# Port Kembla Gas Terminal Submissions Report

February 2019

Australian Industrial Energy  
Port Kembla Gas Terminal

## SUMMER THERMAL PLUME

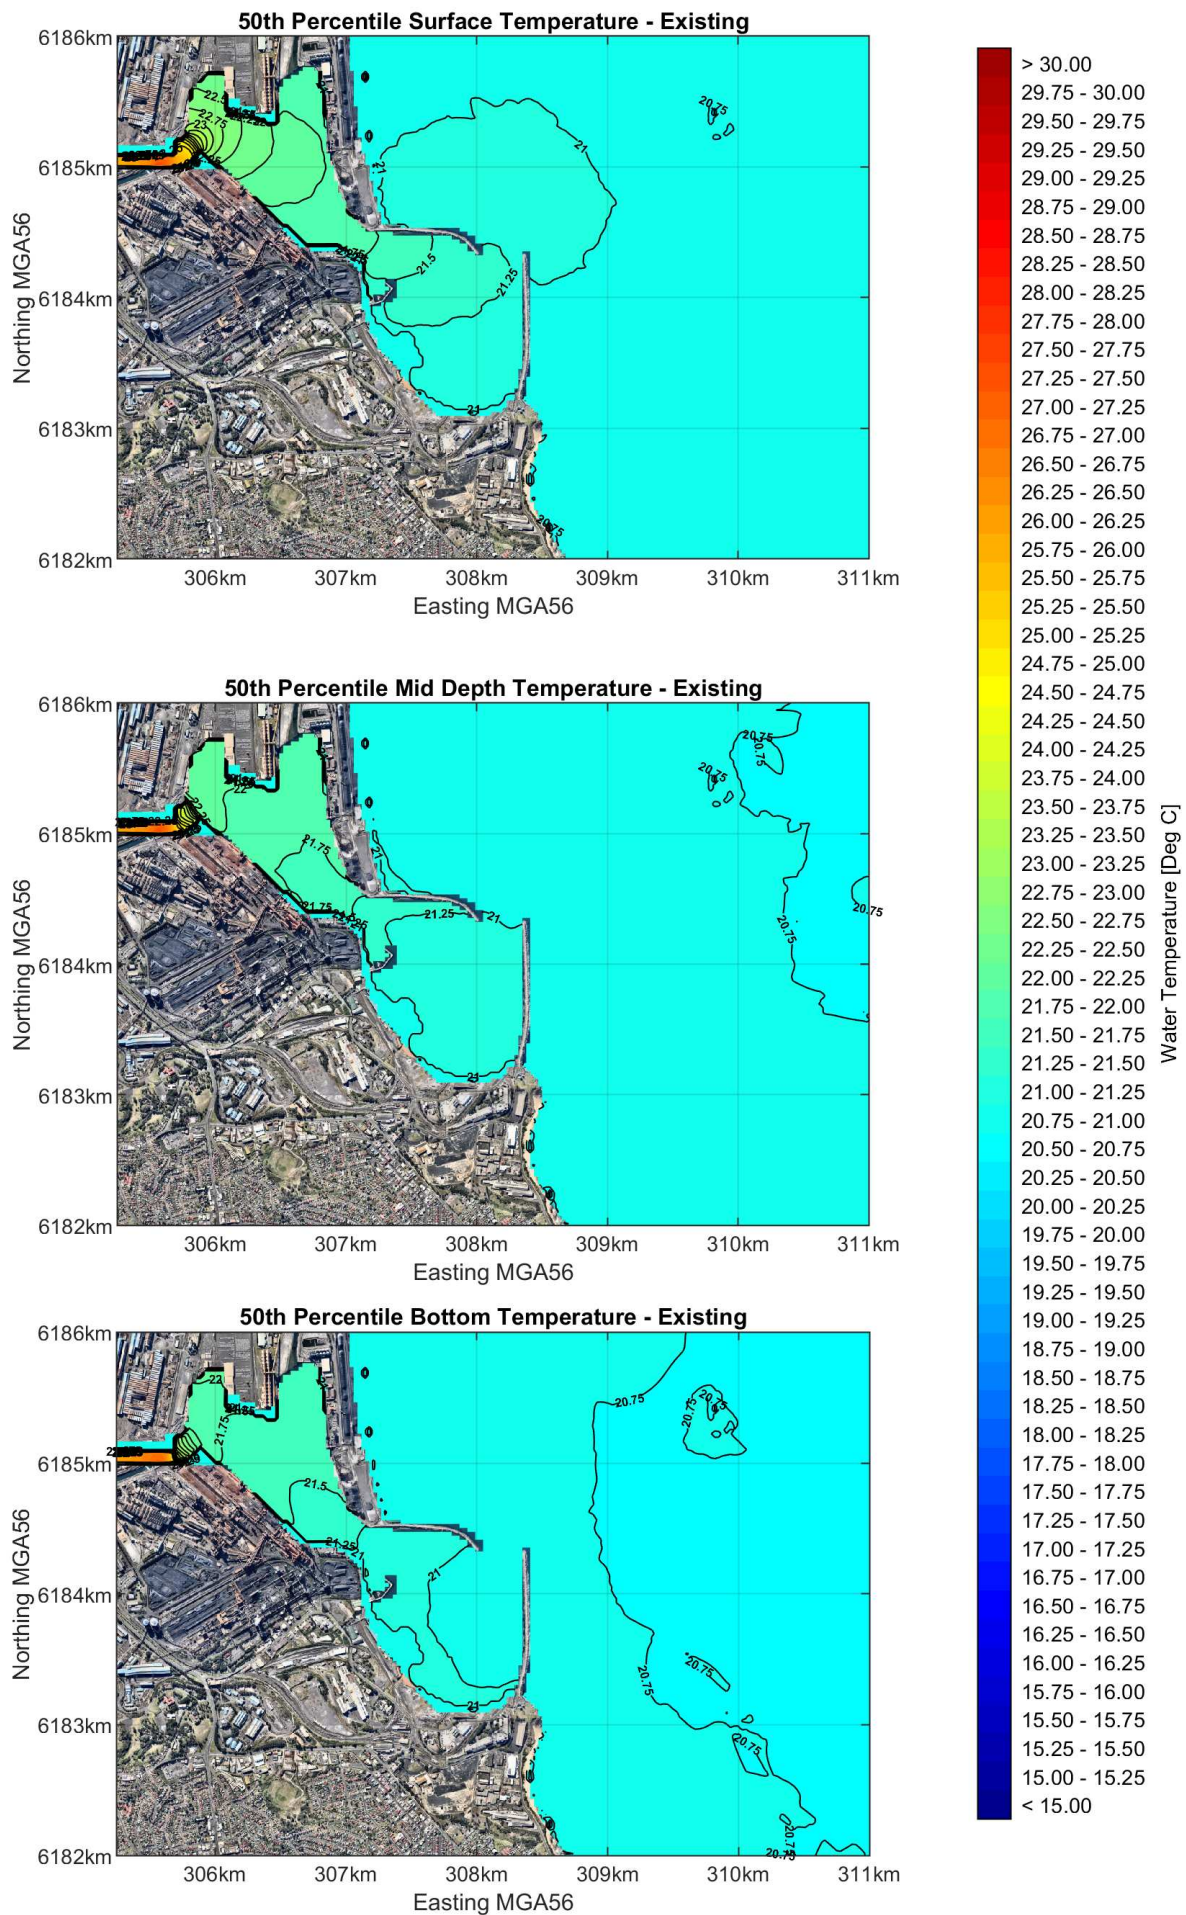
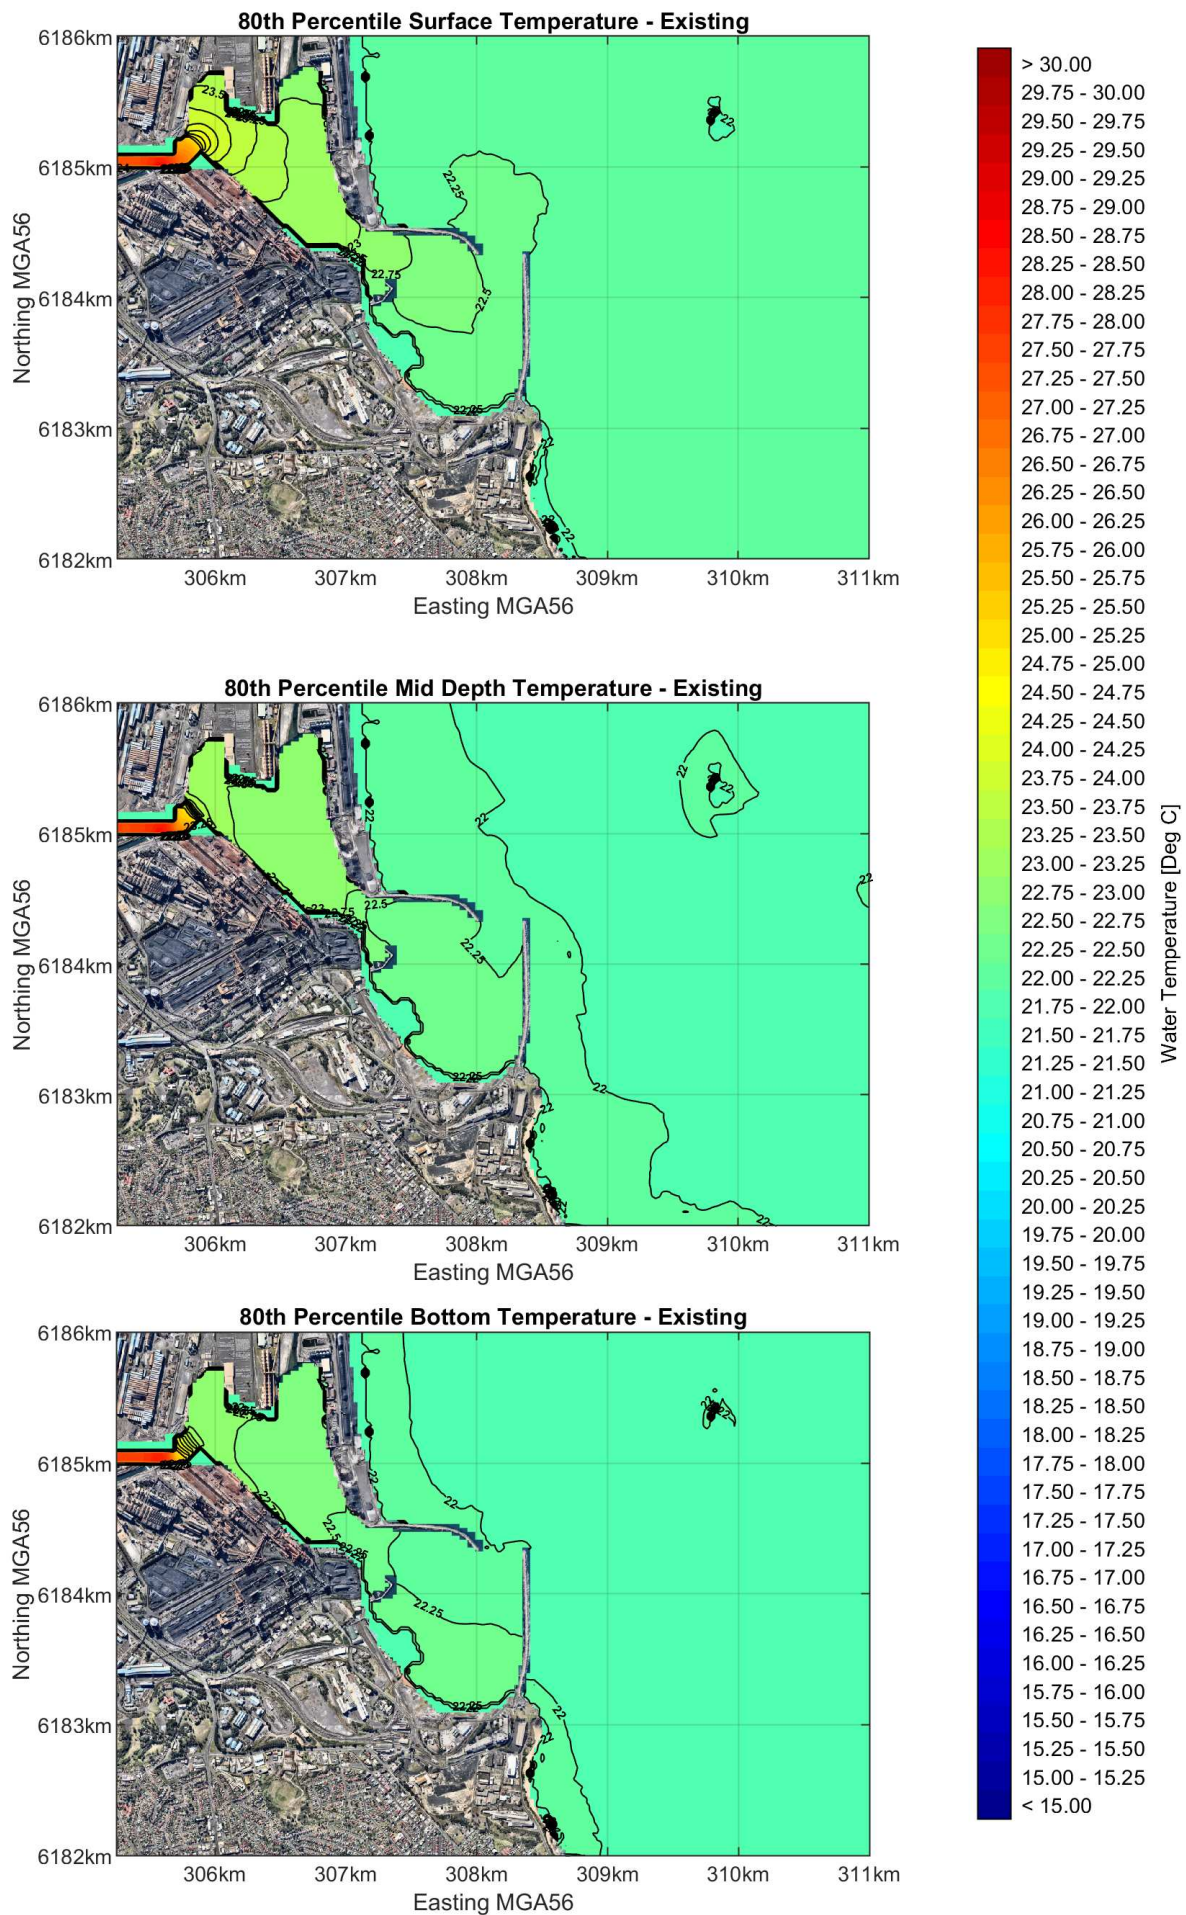
<p><b>Thermal plume charts</b></p> <p>The submission made reference to the thermal plume charts presented in the EIS. It stated the resolution of the charts was limited. It noted the minimum temperature was expressed as “less than 16.5°C” and stated a full range of temperatures including minimums should be presented.</p>	Section 4.2.2
	<p><b>Alternative management measures</b></p> <p>The submission recommended additional measures be considered if there are acute impacts in the mixing zone or water quality objectives are not met at the edge of the near field mixing zone.</p>	Section 4.2.2
